2023/0635

Erection of 1 no detached two storey dwelling and associated works including provision of off street parking and rear garden amenity space

22 Filey Avenue, Royston, Barnsley, S71 4PZ

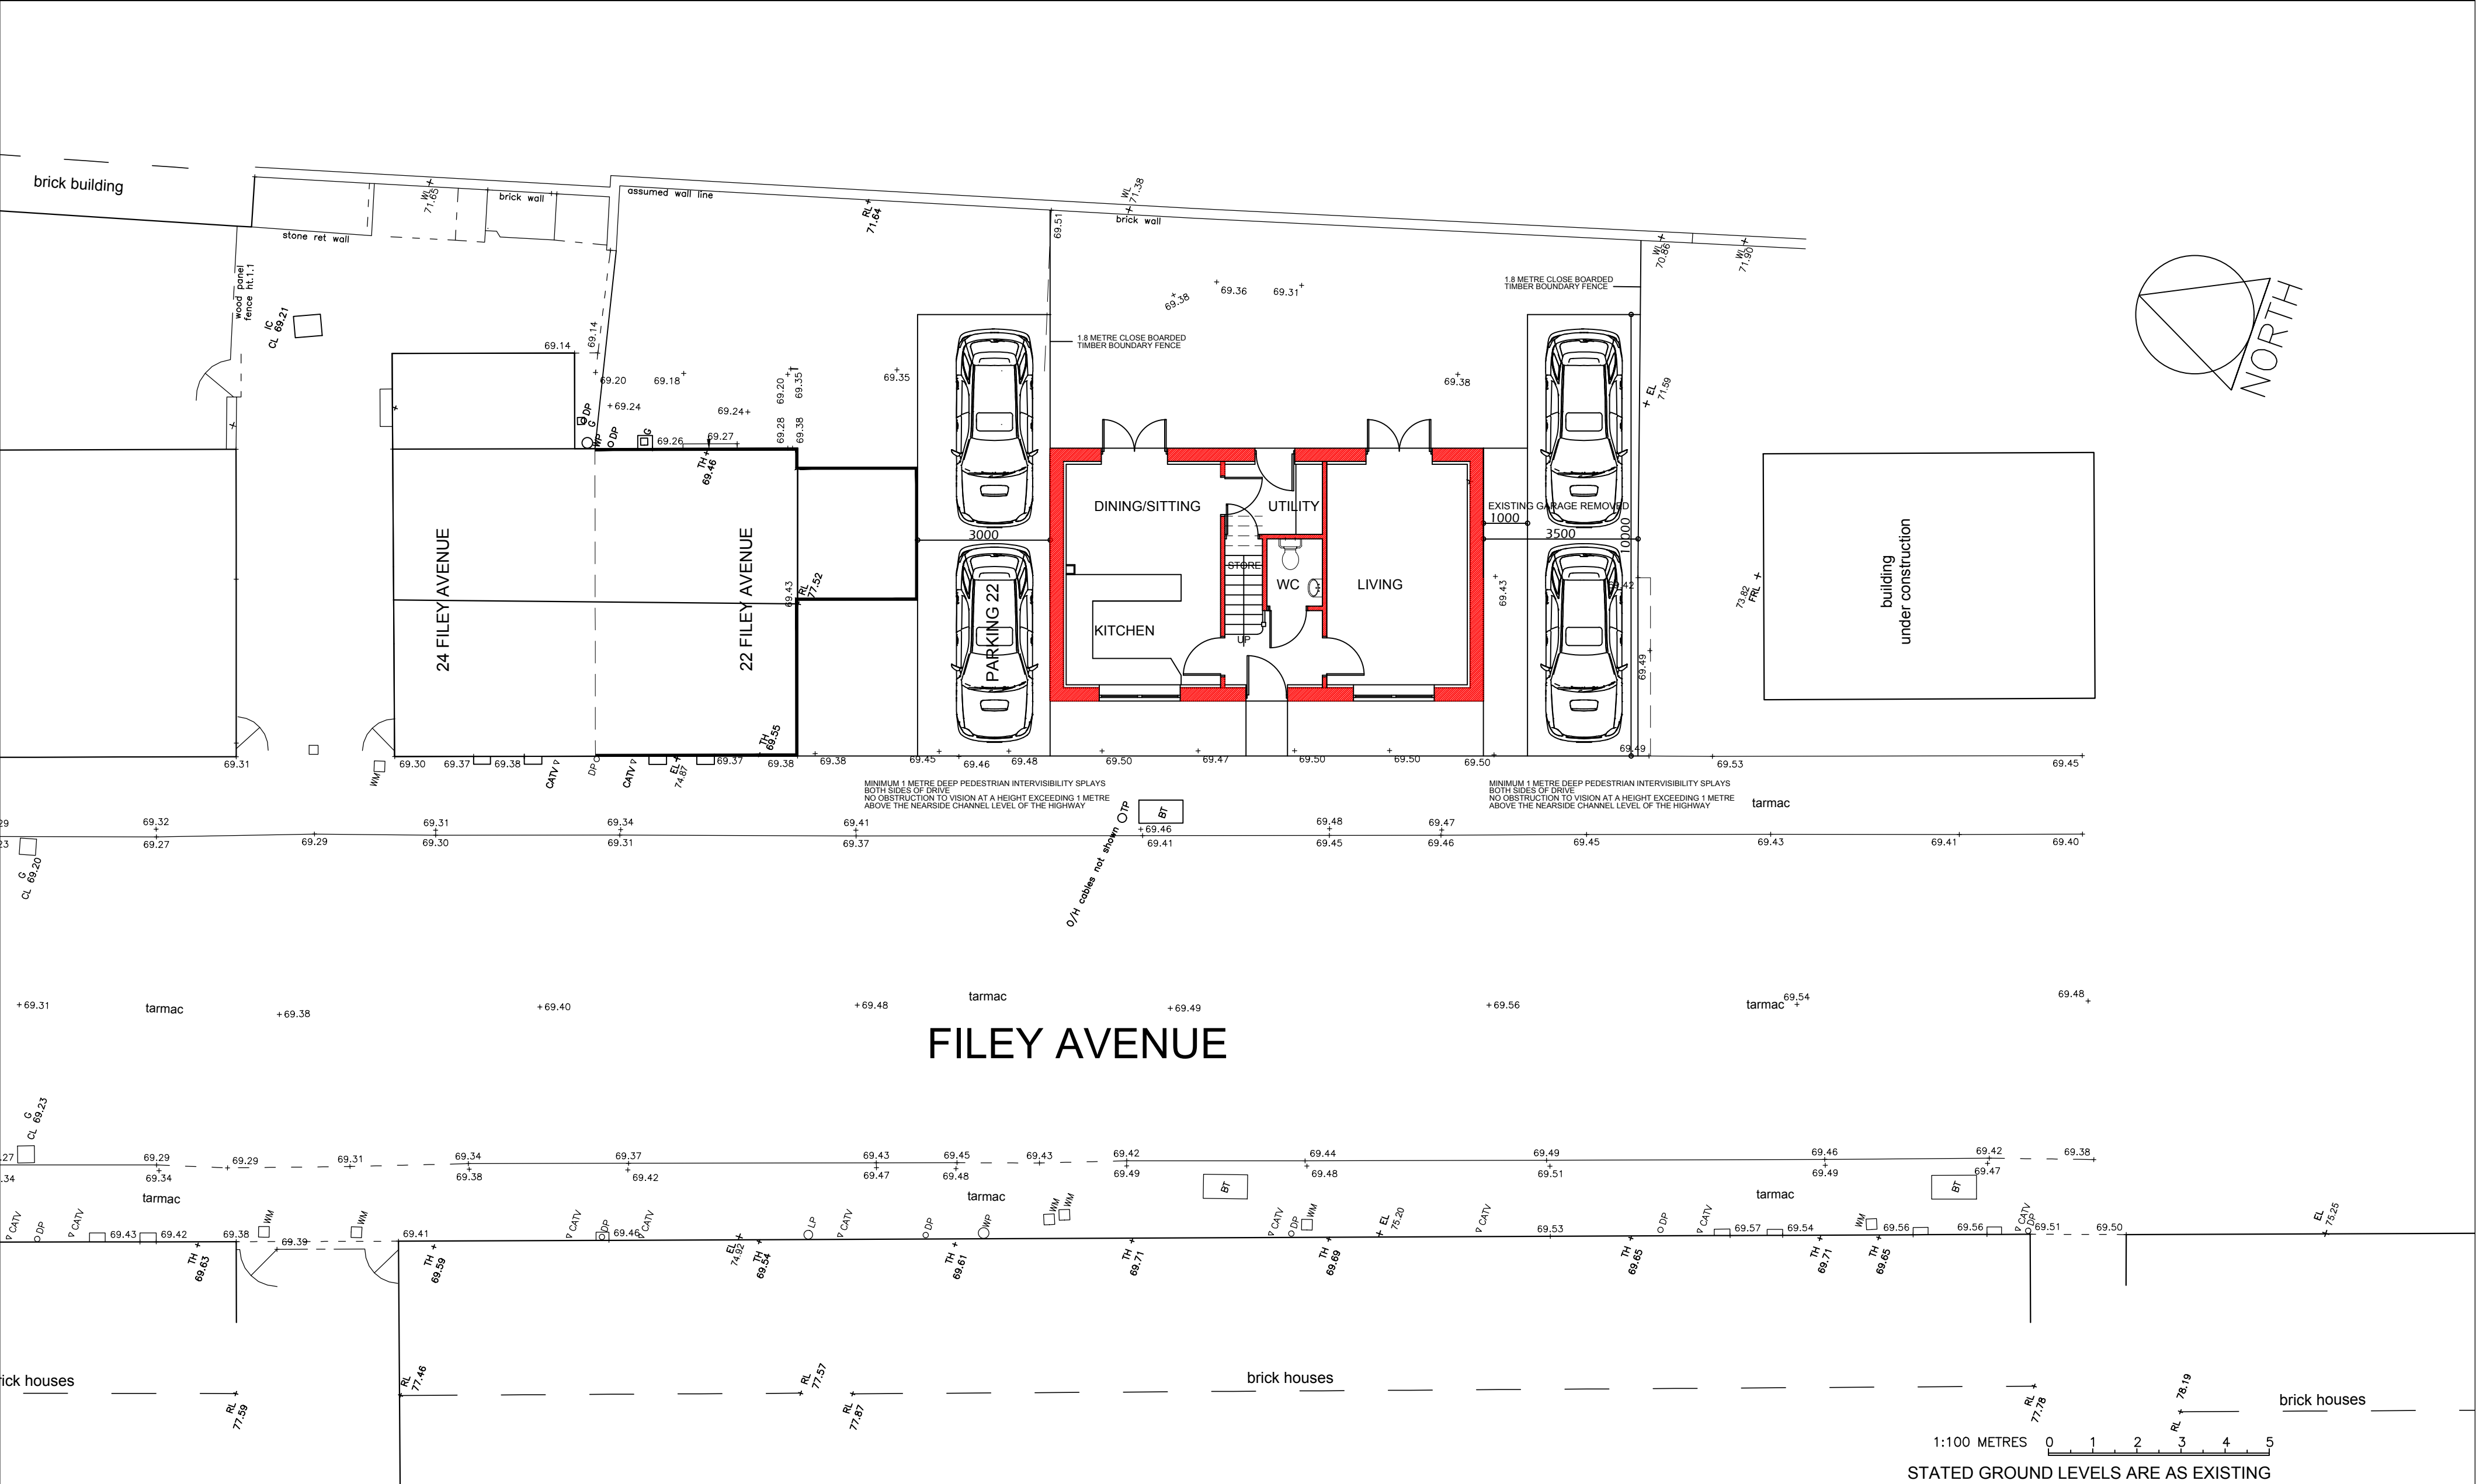
The proposed dwelling is rectangular in shape, set back from the road with parking provision to the side and the amenity space to the rear of the dwelling. It is considered to be similar in appearance to the nearby properties, some of which are immediately adjacent to the road whilst others are setback with a garden/soft landscaping area positioned in the frontage. The proposed development will therefore be similar to the surrounding area in terms of its overall layout, in relation to the road. The proposed layout is considered appropriate but does not include details of soft landscaping or boundary treatments to the frontage. Details of which will need to be submitted and agreed by the LPA, upon commencement of development. The position of the parking to the side is acceptable, and welcomed as this allows for design/landscaping features to be positioned to the frontage and is in line with the South Yorkshire Residential Design Guide. A planning condition will be attached which requires the parking area be hard surfaced.

The proposed development includes 2 x parking spaces which is in line with the Council's Parking SPD for a dwelling of this bedroom size. Additionally, the development will include two parking spaces within the side curtilage of the existing/host dwelling at no. 22, which increases the off-street parking provision compared with the existing relationship for the host dwelling. The parking provision is therefore considered to be in line with Local Planning Policies and is acceptable, with highways raising no objection subject to a condition requiring that the parking/access area is to be hard surfaced, and adequately drained.
